RE: Building Permit: BP-2022-17740

This letter is intended to provide you with a justification for the changes which have occurred on the View House project Permit# BP- 2022-17740. We request your approval for the minor modifications made to the Clubhouse building as to design and height outlined in detail below.

**Updates to recreational building height and design**

REC/LEASING
PRELIMINARY ELEVATIONS

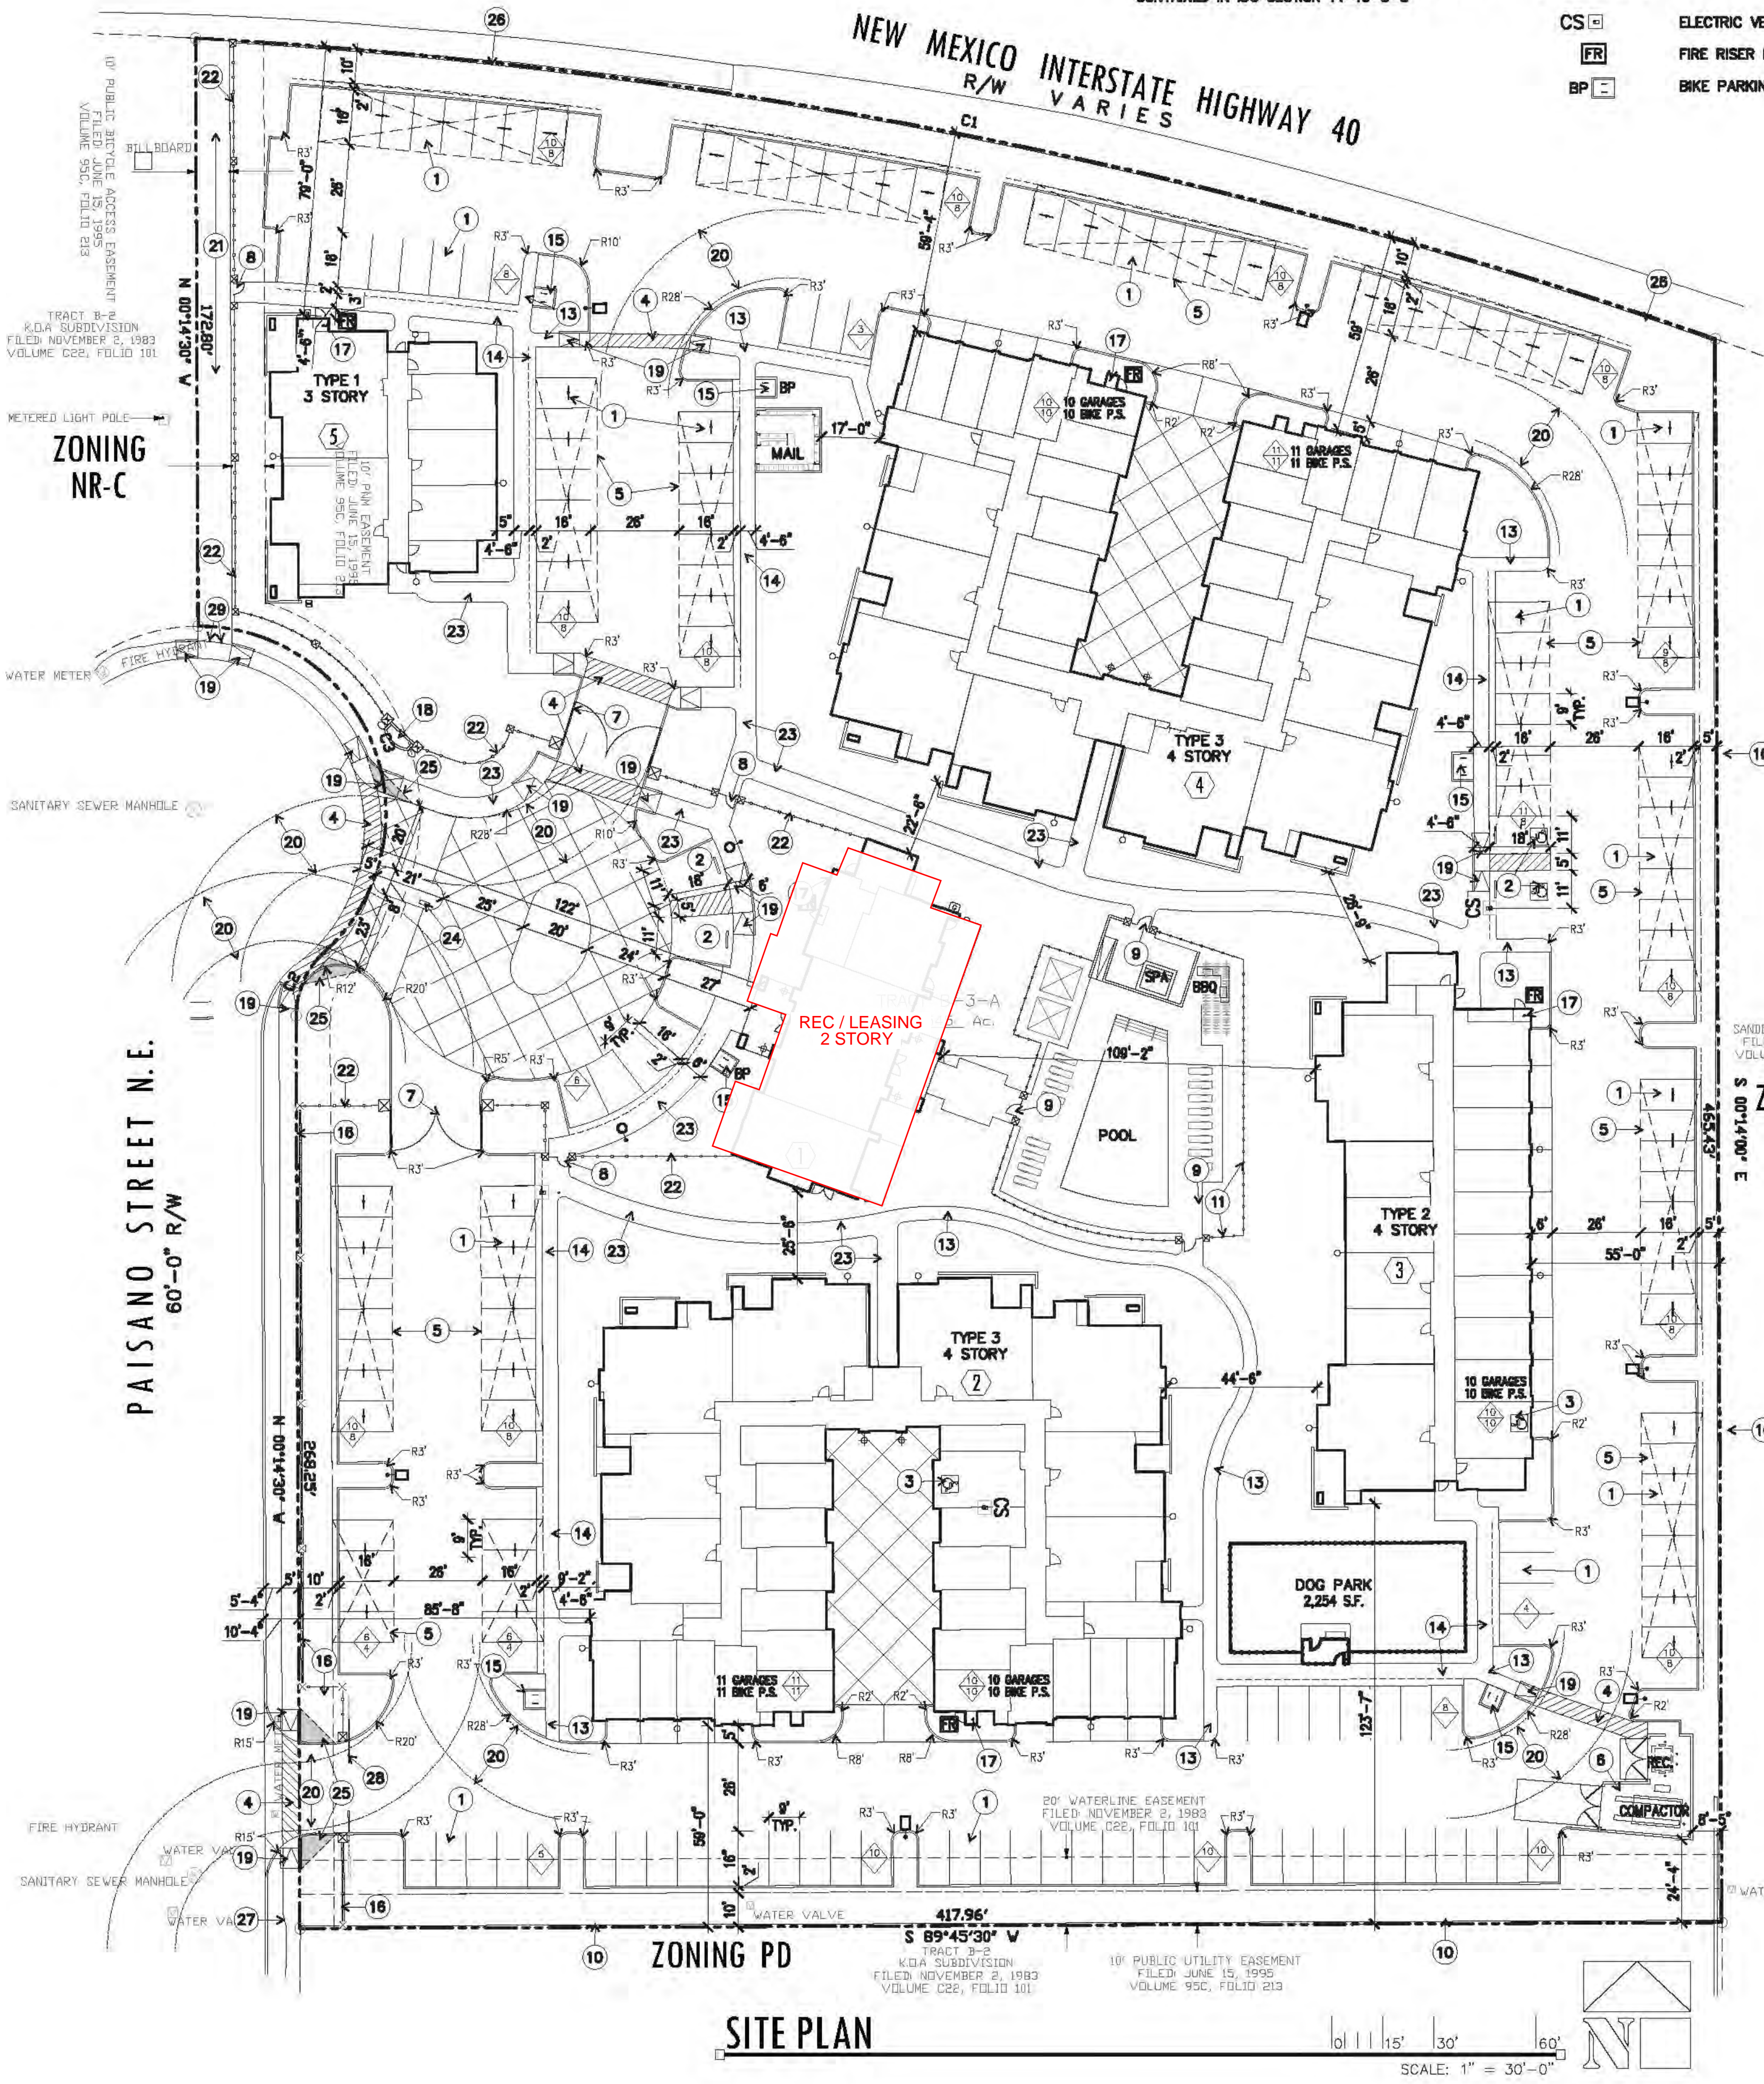
- The top of parapet was increased an additional 4 feet from 22ft to 26ft.
- The majority of the steep pitched roofs were replaced by flat roofs and a second story.
- The second story was added to provide additional multifunction space for residents who may use the area for study, meetings, leisure or work.
- We believe all changes are in accordance with the IDO and are minor changes to the previously approved site development plan.
